NSW RURAL FIRE SERVICE

Your reference: MP 08_0167 Mod 3

Modification to Project Approval (MP 08_0167 Mod 3) – Belle O'Connor Street, South West Rocks

File ref:W:\5144P SALTWATER LINKS\IP- PLANS\BOUNDARY ADJUST S96 PLANS\5144_BOUNDARY ADJUST PLANS_7.2.17DWG.DWG

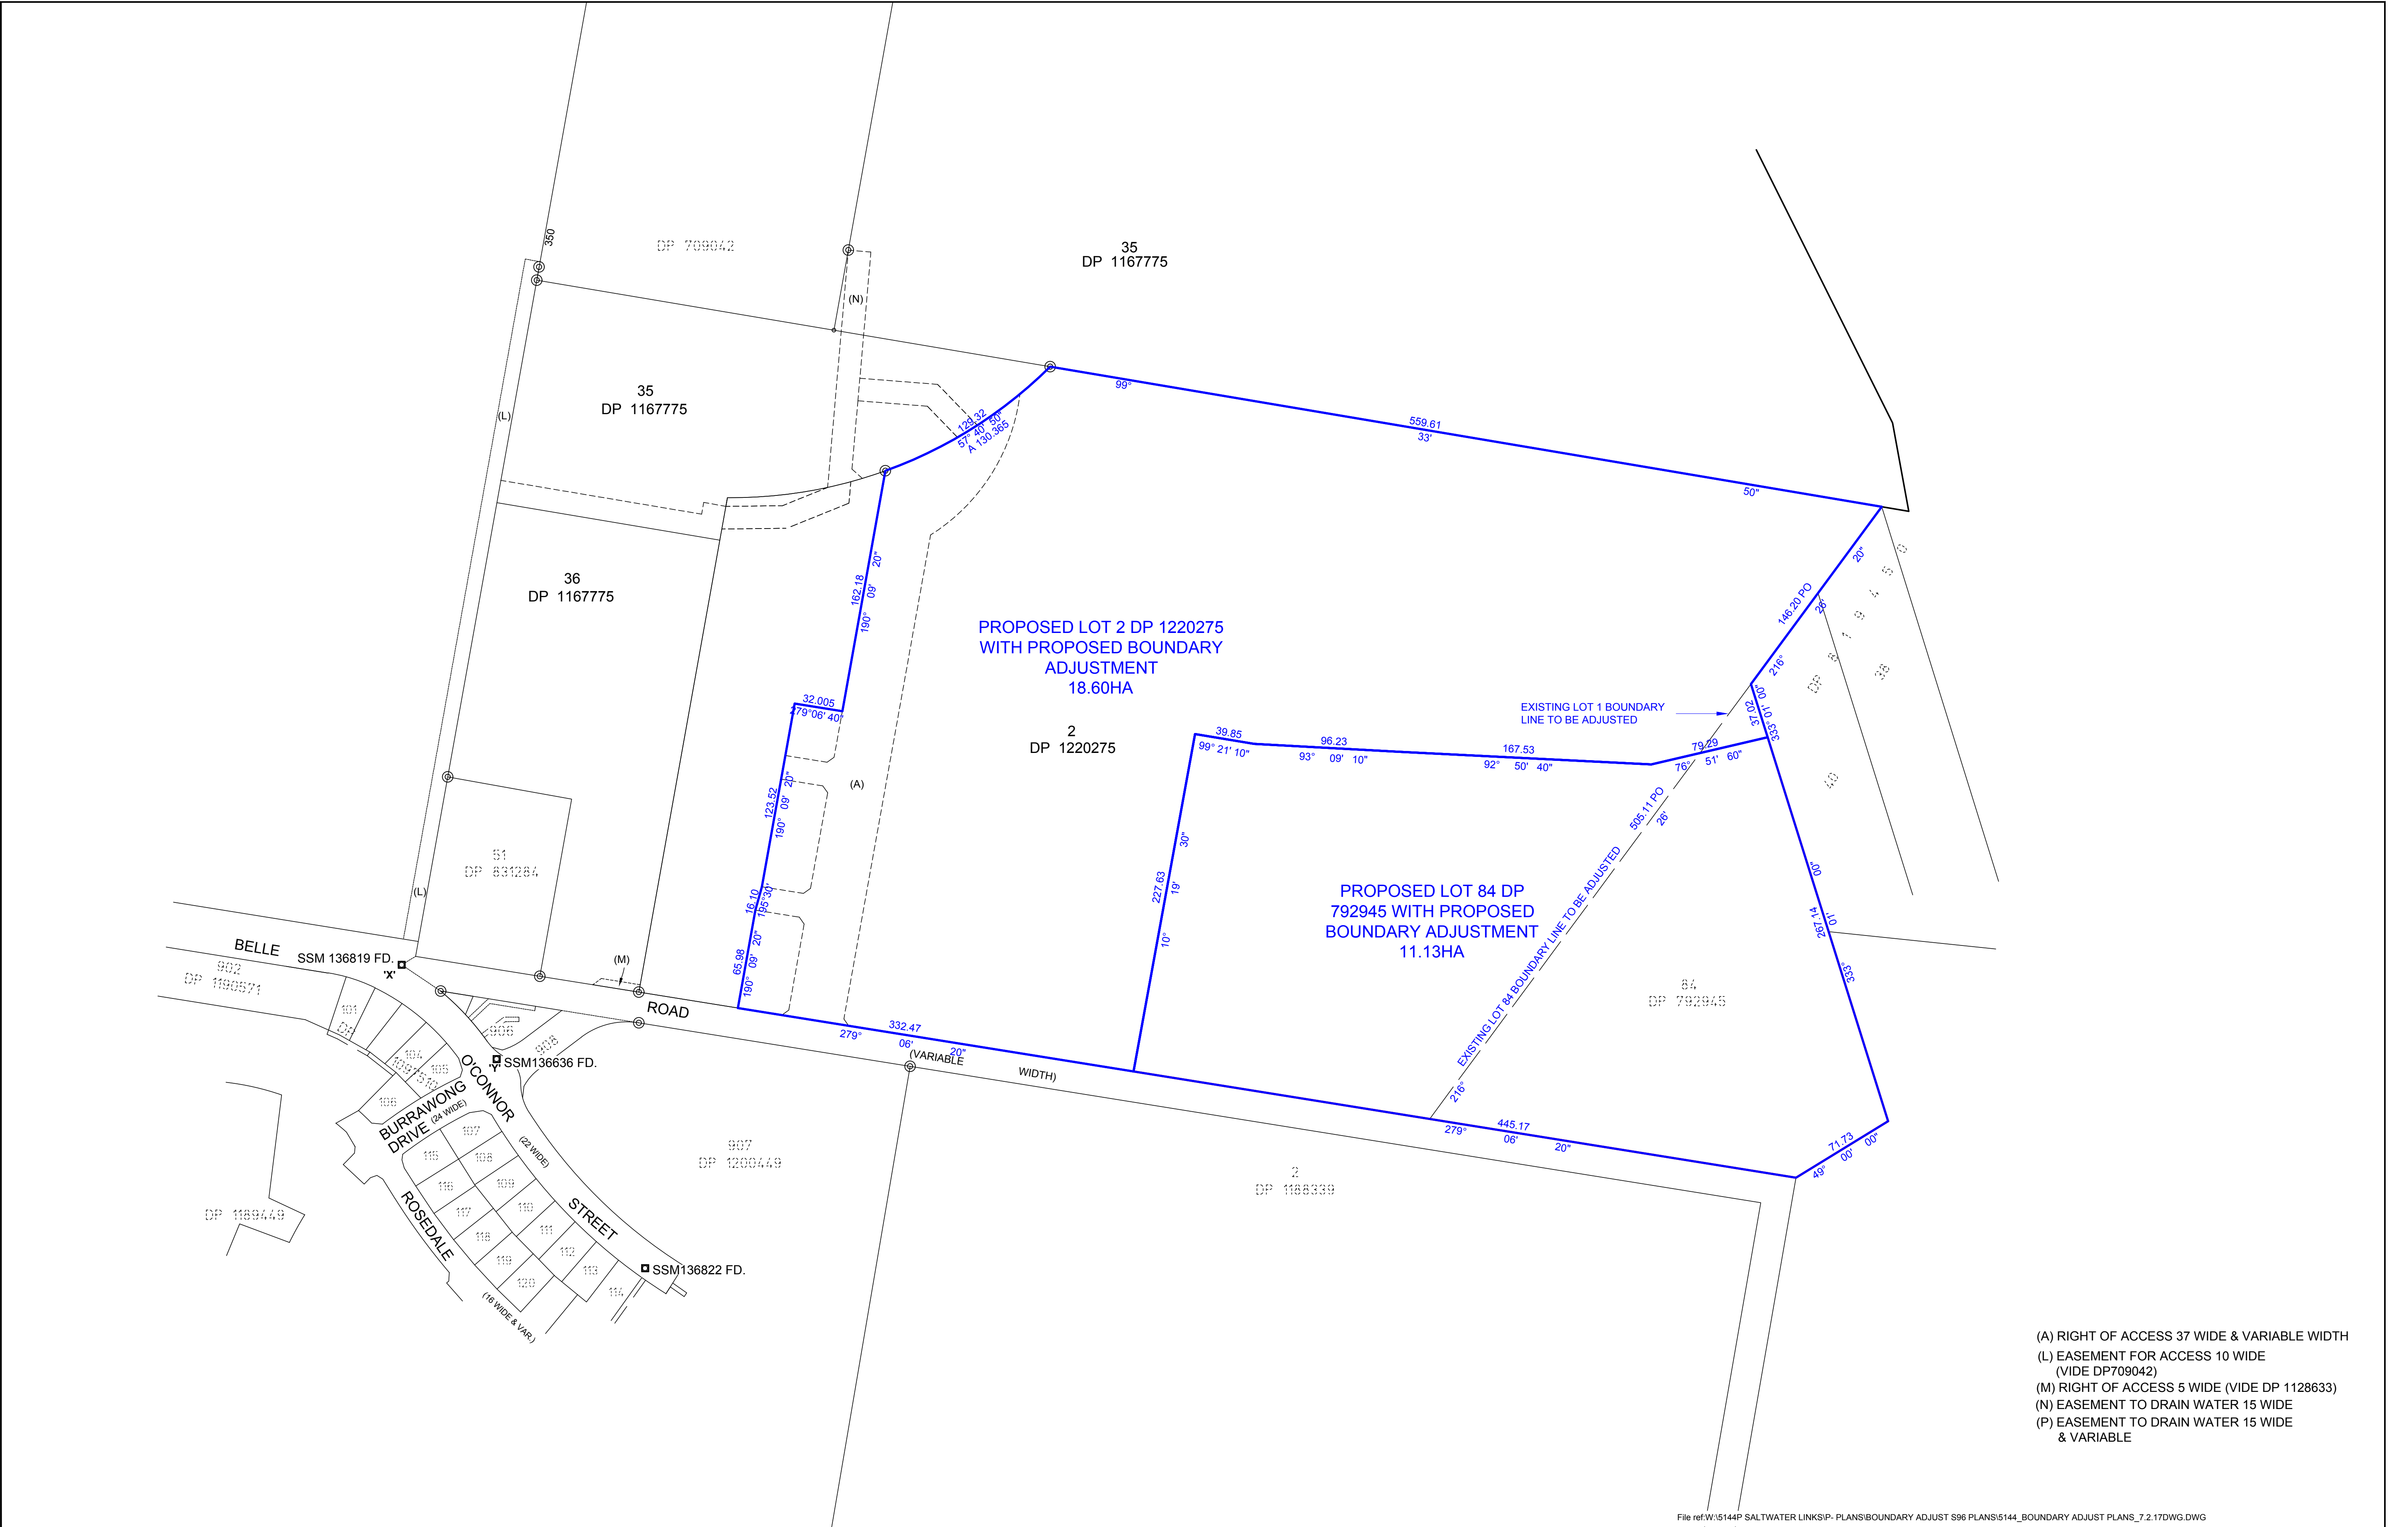
- The vegetation to the south of the site is a mixture of woodland and grassland and should be assessed accordingly.
- The proposed asset protection zone to the east is partly located on adjoining land and part of the area proposed as an asset protection zone does not meet the specifications for an inner protection area. Furthermore, no evidence has been provided that the proposed asset protection zone will be subject to ongoing management as an inner protection area. The applicant is required to address section 3.3 of 'Planning for Bush Fire Protection 2006'.

- A perimeter road should be provided along the eastern and south-eastern boundary adjacent to any areas of unmanaged vegetation.
- A plan showing road width dimensions in accordance with 'Planning for Bush Fire Protection 2006' is to be provided.
